From: Martyn White
Sent: 28 February 2019 12:44
To: Planning.Responses
Cc: Anita Gardner
Subject: M/153/18

M/153/18

The application is for 1 new dwelling with a detached garage within the Middleton-on-Sea estate. The estate has been identified as an Area of Character in the adopted Local Plan (2018), and as a consequence, is considered to be a non-designated heritage asset.

Proposed East Elevation in Context 1:200@ A3

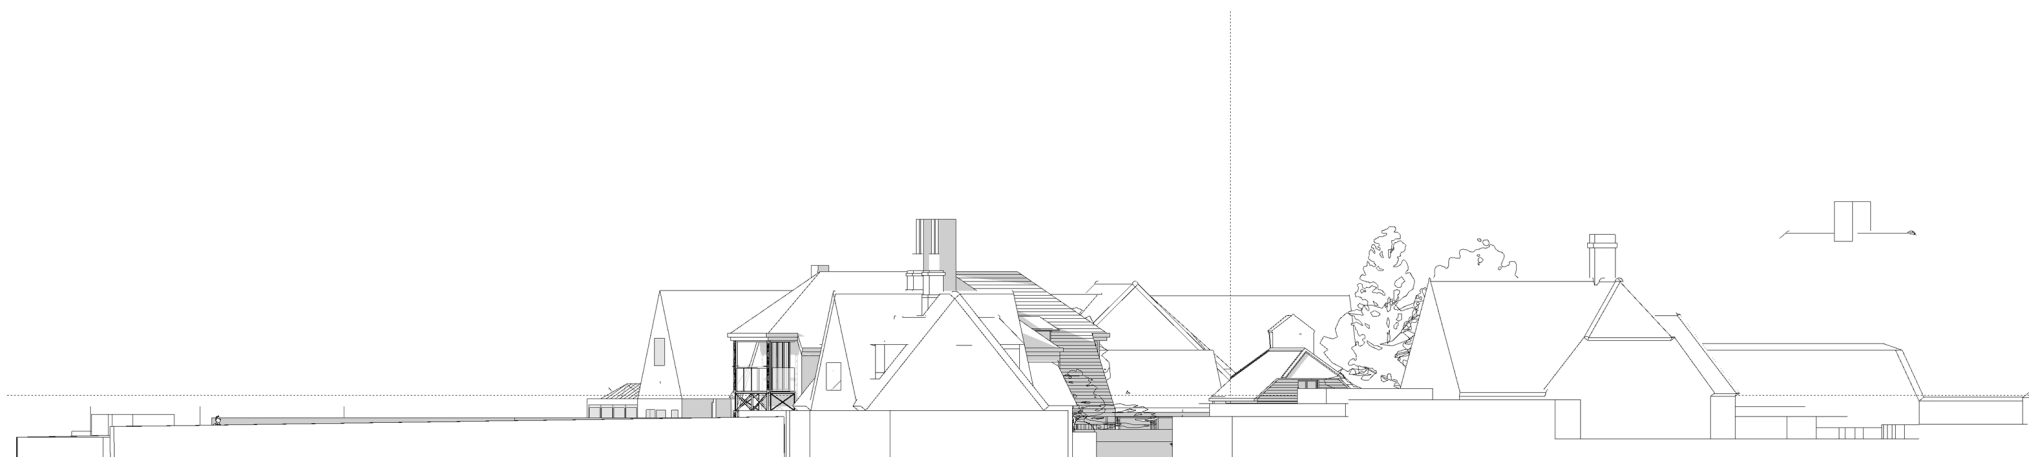
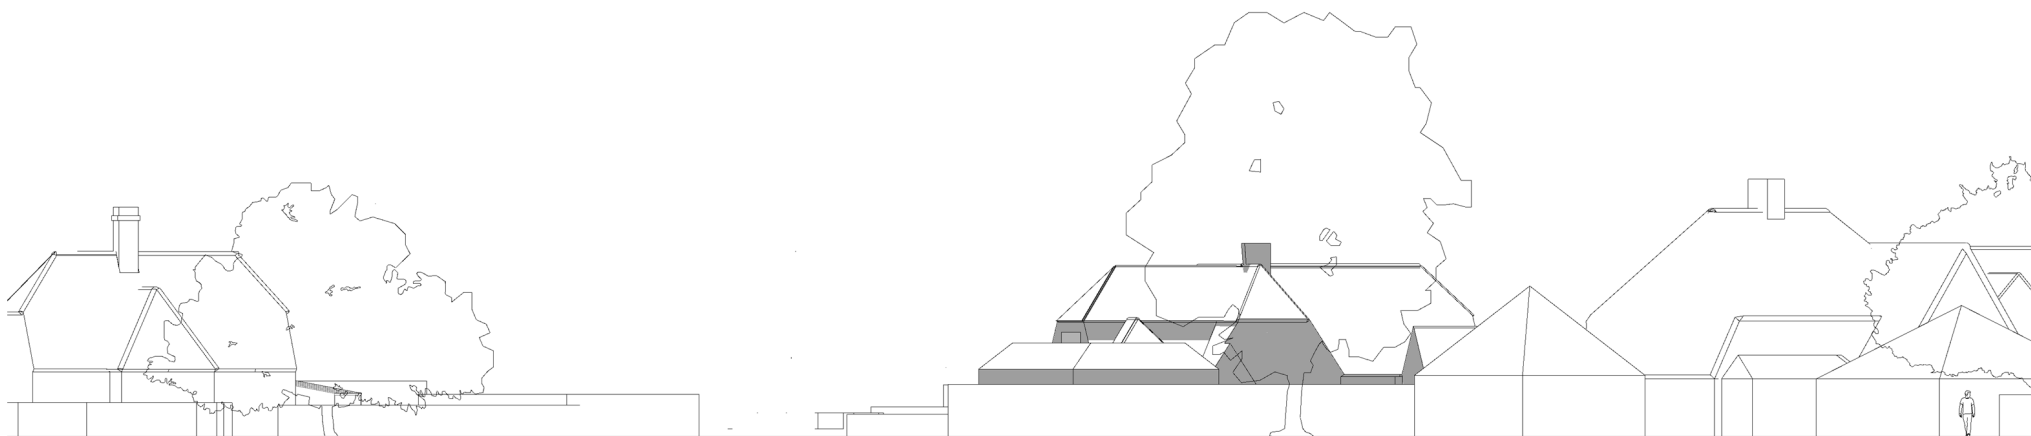
For instance, I note that the proposed dwelling is substantial in size, and occupies a significant amount of the plot, as opposed to most in the local area. Further, it is substantially taller than the neighbouring property (number 46), which would mean that it would dominate this part of the local area.

The elevations show the garage structure in the context of the façade, and the proposed boundary treatment on the black and white elevation drawings. This results in elements of the relevant façade missing from assessment. This is unfortunate and revised plans should be submitted.

**Proposed Landscaping
and Car Parking
1:250**

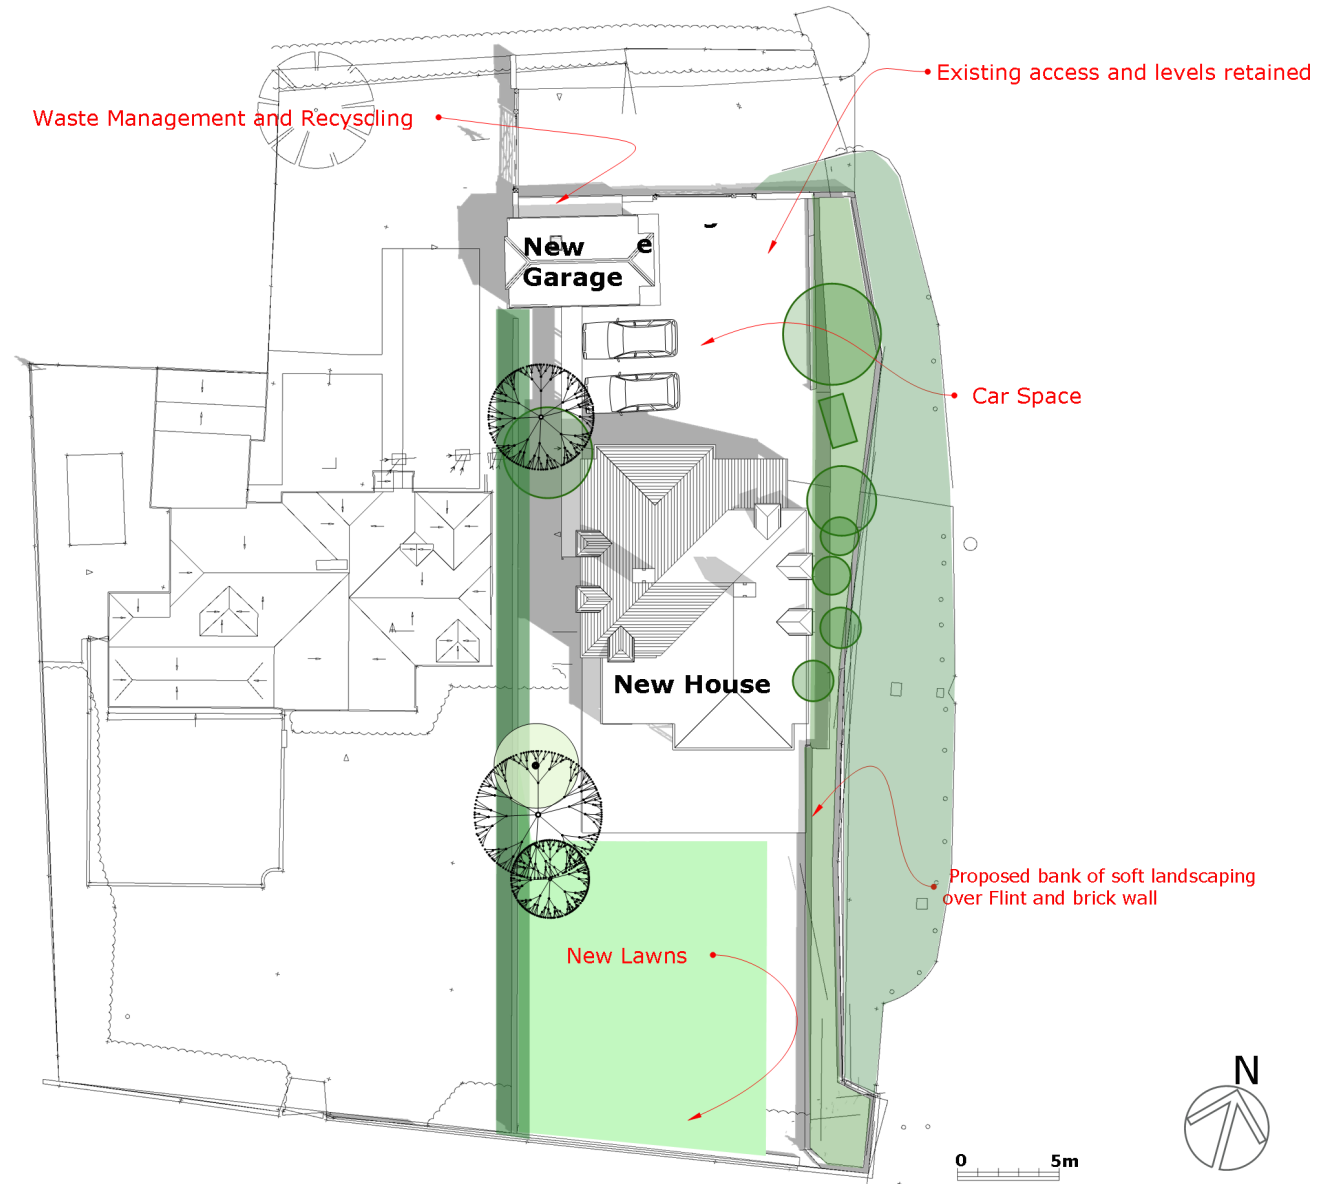
I note that reference is made to the provision of a flint wall and bank of soft landscaping as part of the landscape plan, yet it is not fully clear how this will look like. Whilst the concept of traditional materials appears to be acceptable, such a proposal will require further information.

**Elevation Materials
South**

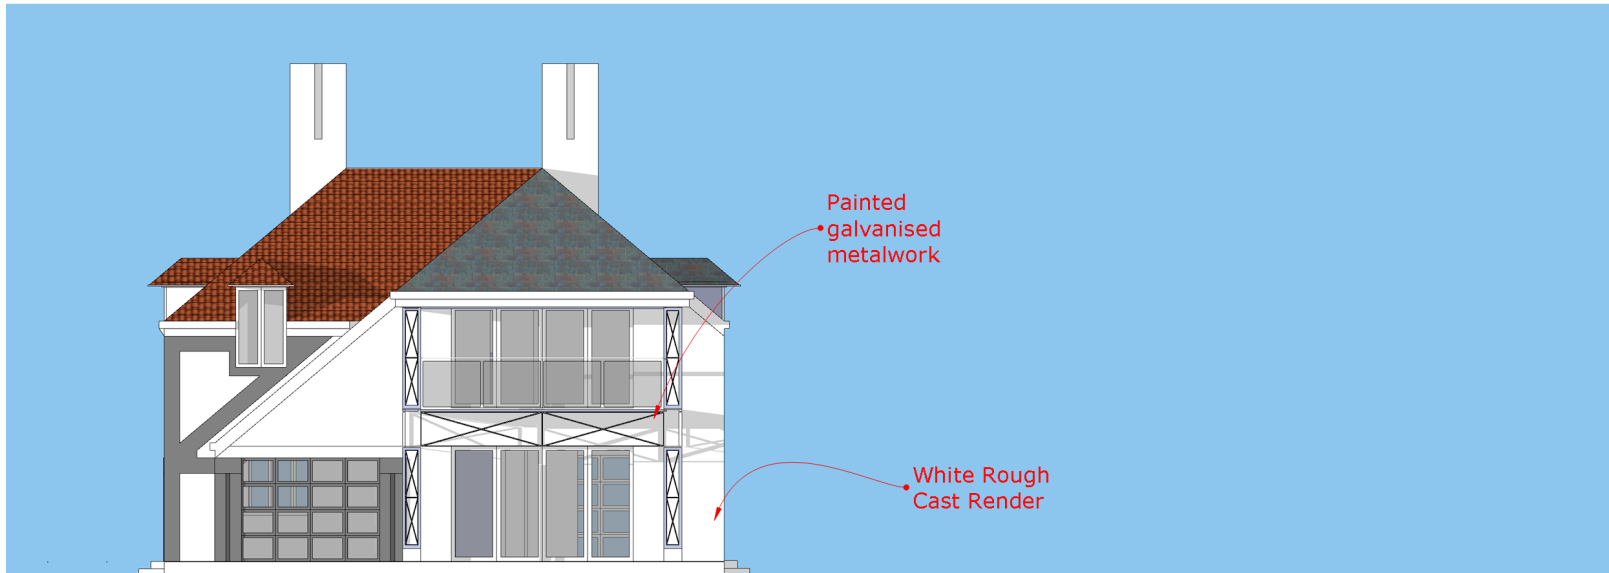
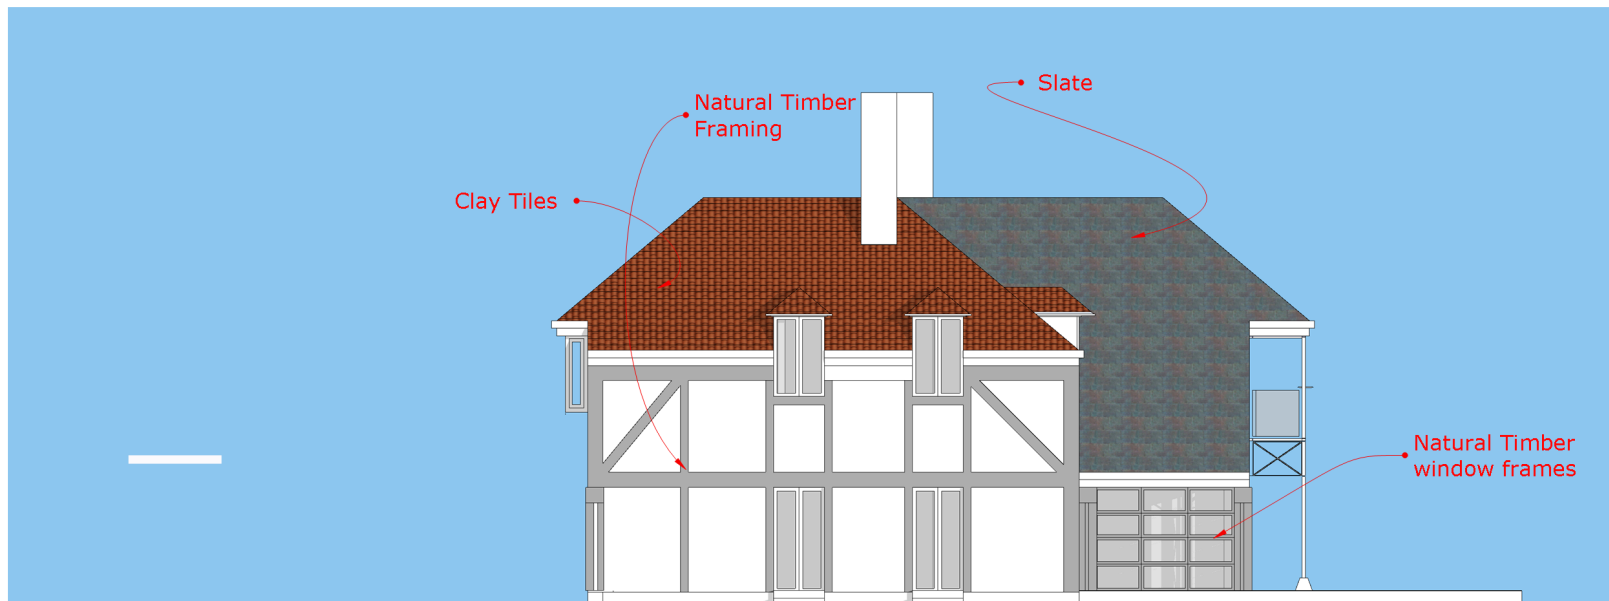
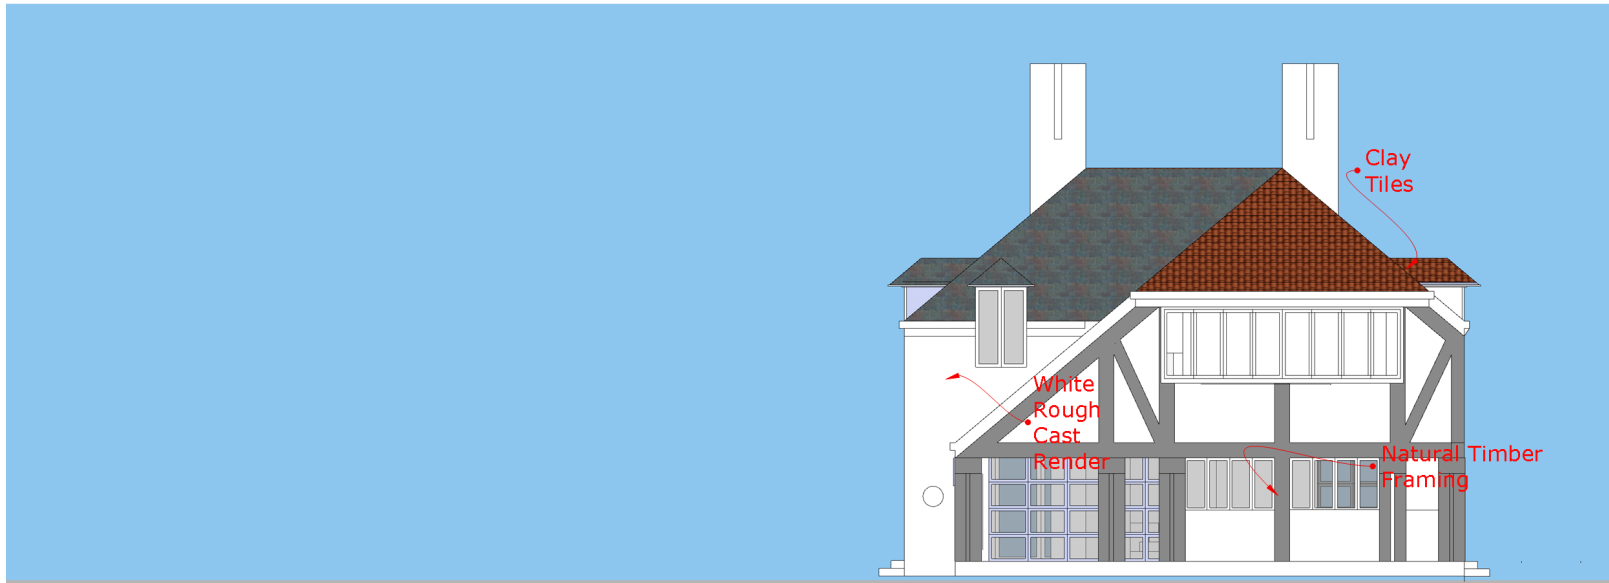
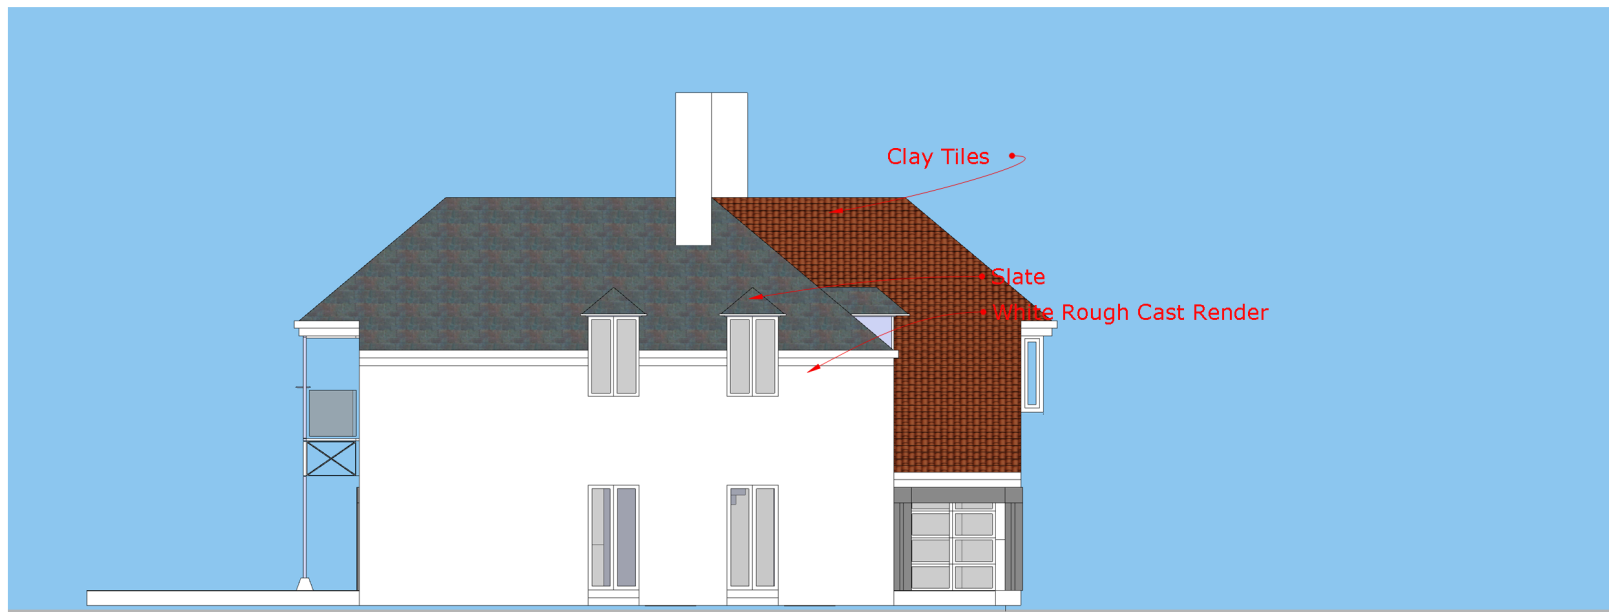
Whilst a more traditional appearance is proposed, it is not clear why a half-timbered elevation is now being considered, or why both slate and clay tiles are suggested, when the immediate properties are rendered with either clay or thatched roofs. It is considered that this, along with the stone quoining, glass balconies, shutters and roof, creates a series of complex elevations which would be in conflict with the established character of the local area.
